## Engineers Comments Regarding Surface Water Drainage

<b>Application Reference:</b>	CM/12/25/PL	<b>Reviewer Reference:</b>	ADC/SB
<b>Planning Officer:</b>	Kathryn Welch	<b>Date of Review:</b>	07/08/2025
<b>Site Name:</b>	Rigates Climping Street Climping BN17 5RQ		
<b>Application Description:</b>	Demolition existing buildings and erection of 1 No. self / custom build dwelling and garage with associated landscaping. This application may affect the setting of a listed building, is in CIL zone 5 and is CIL liable as a new dwelling.		
<b>Assessment Number:</b>	1 of 1

DWG TITLE
INDICATIVE SURFACE WATER DRAINAGE LAYOUT

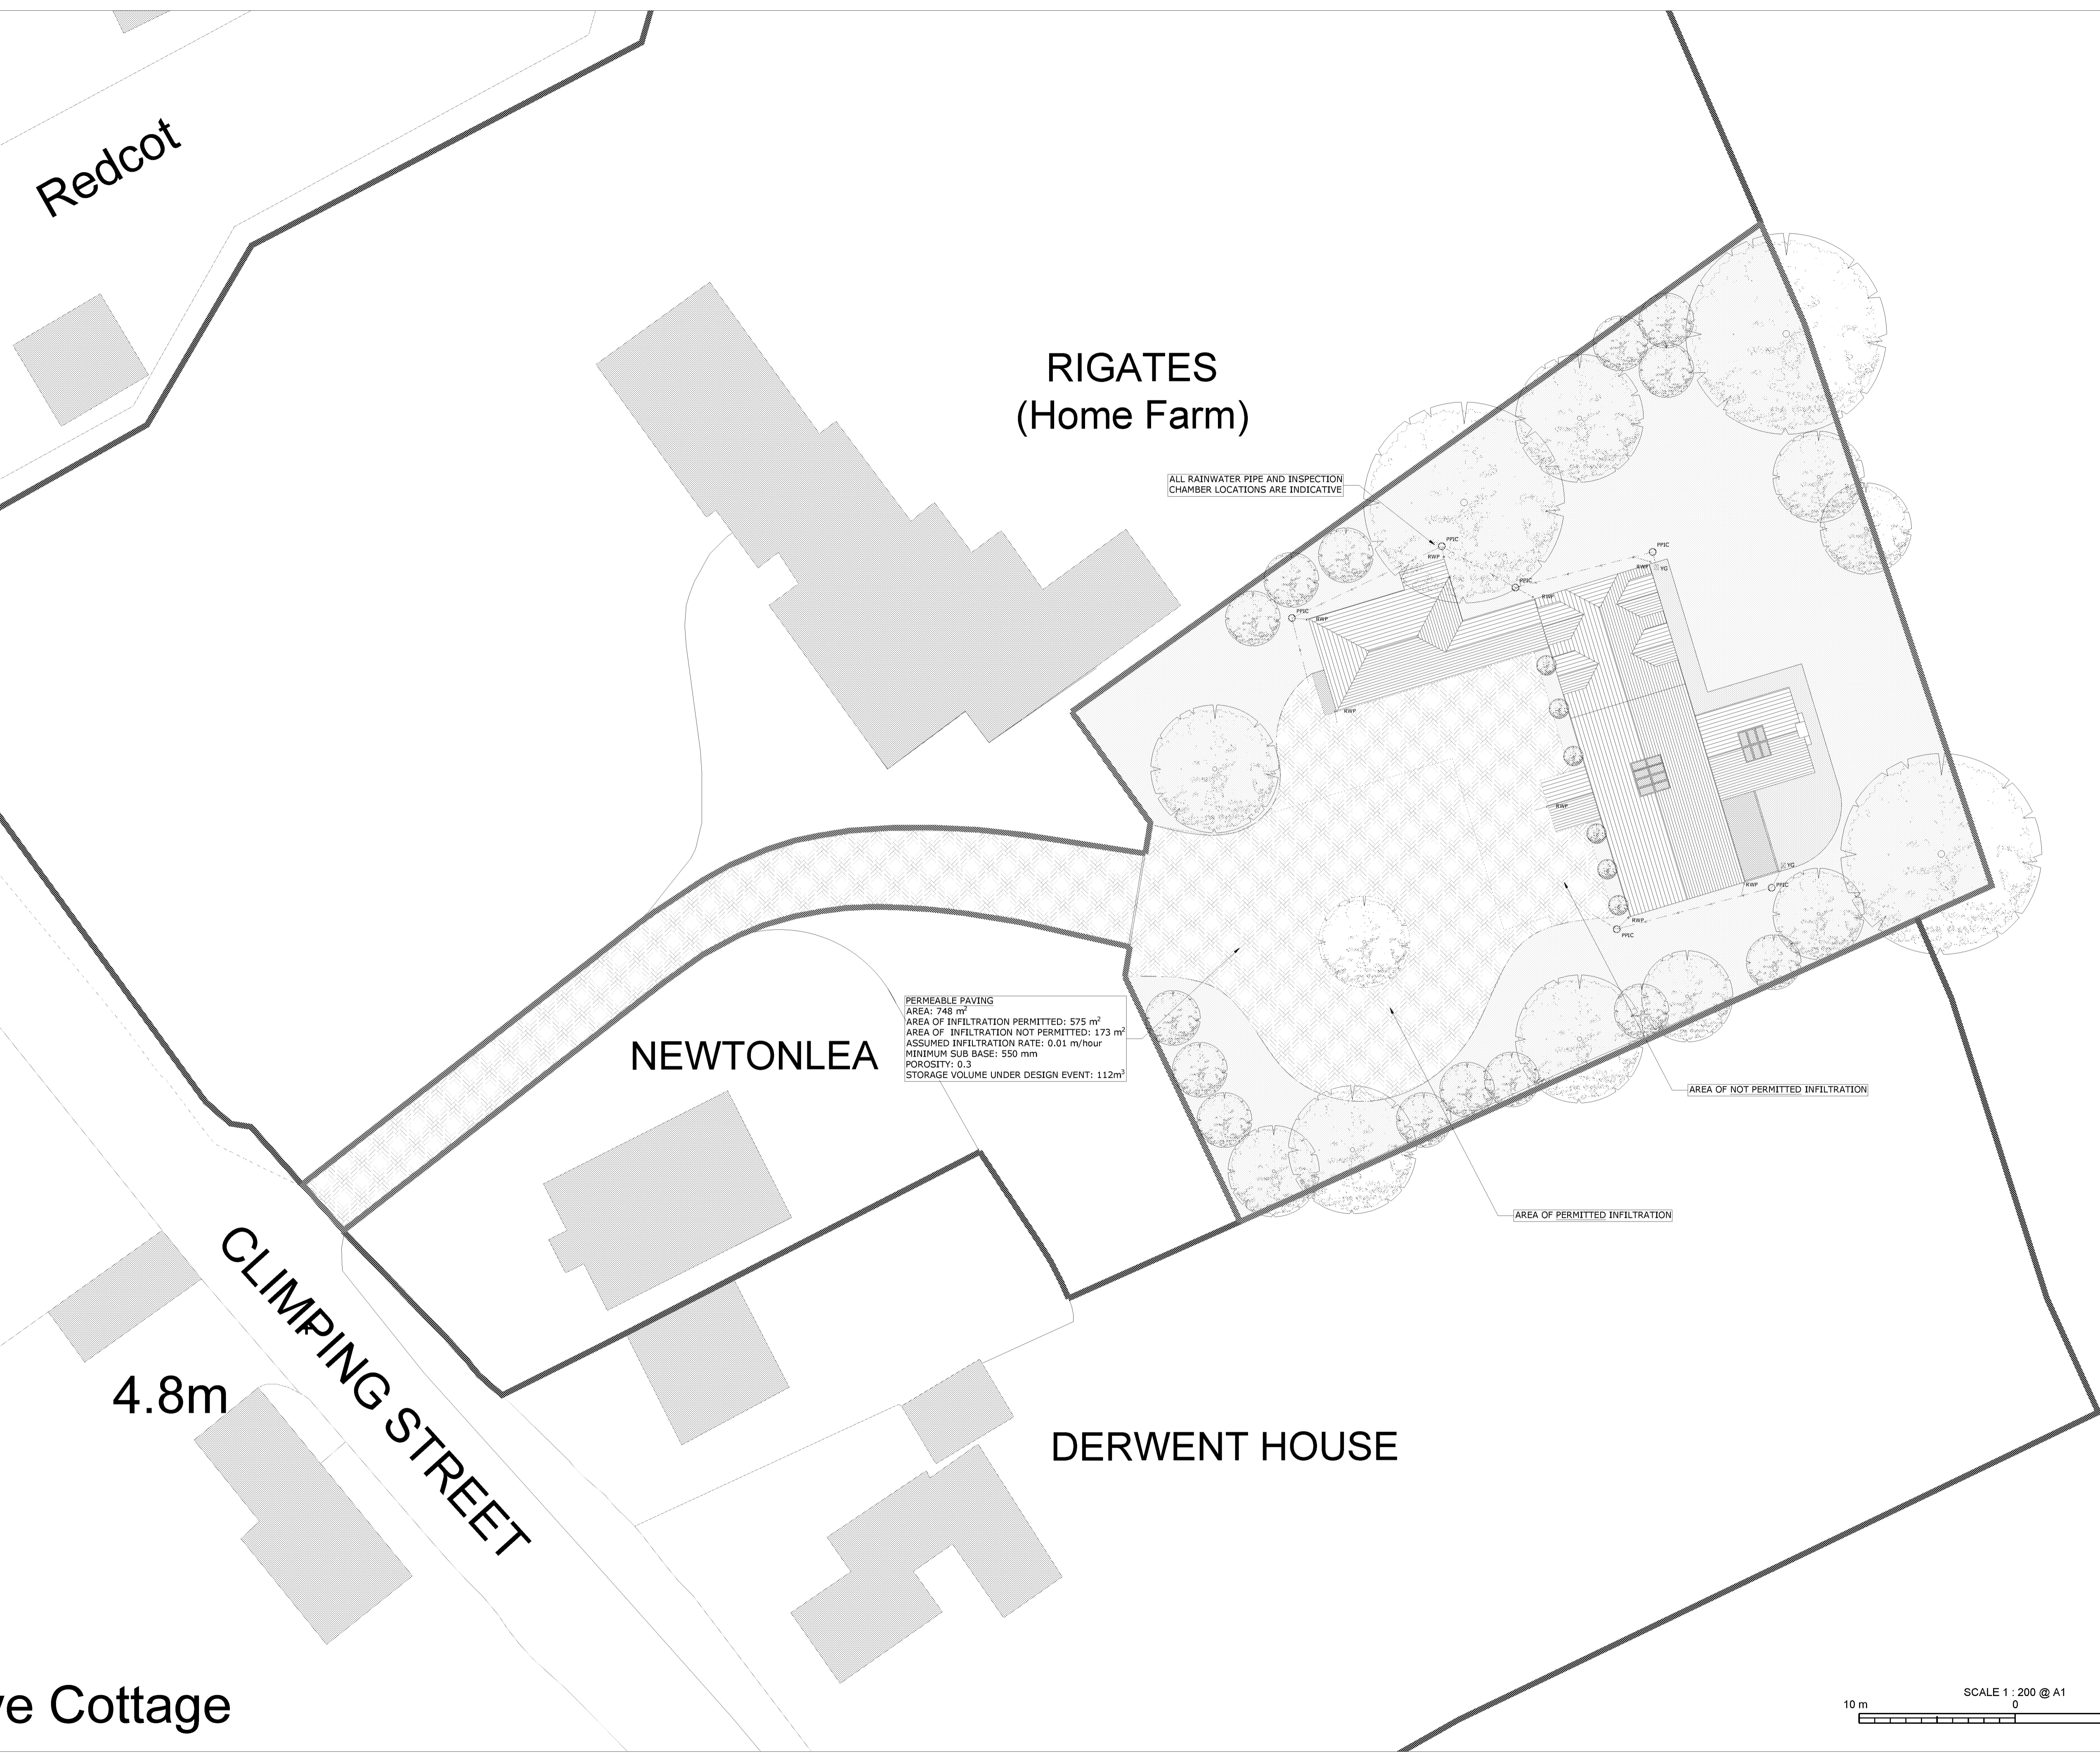
A surface water drainage strategy has been submitted that relies on infiltration as a means of disposal. No indication of likely groundwater levels have been submitted and therefore it is unknown if 1m of unsaturated ground can be achieved between the base of the proposed permeable paving and the peak groundwater level. If this cannot be achieved, then an alternative design will need to be submitted for approval.

The submitted infiltration testing was completed in summer, so if groundwater levels are low enough then the testing will need to be repeated in winter to represent worst case conditions in accordance with BRE DG 365. The summer testing is an early indication that shallow infiltration may be viable, however the results cannot be used for the design rates.

There is a public surface water sewer on Climping Street adjacent to the site boundary which the applicant may connect to if infiltration is later found to not be viable. The invert levels and capacity of this sewer are unknown. Ideally these would both be confirmed prior to determination to avoid risk. The planning officer should be aware that if infiltration is not viable and connection cannot be made to the surface water sewer then flood risk may be increased by the proposed development as there are no alternative disposal locations.

1. Winter groundwater monitoring,
2. Winter infiltration testing strictly in accordance with BRE DG 365 or similar approved,
3. Details of the proposed method and location of surface water disposal, in accordance with the SuDS hierarchy,
4. Impermeable area plan,
5. Calculations modelling the surface water drainage network for the following storm events:
  - a) 100% Annual Exceedance Probability [AEP]
  - b) 10% AEP + climate change allowance
  - c) 3.3% AEP + climate change allowance
  - d) 1% AEP + climate change allowance
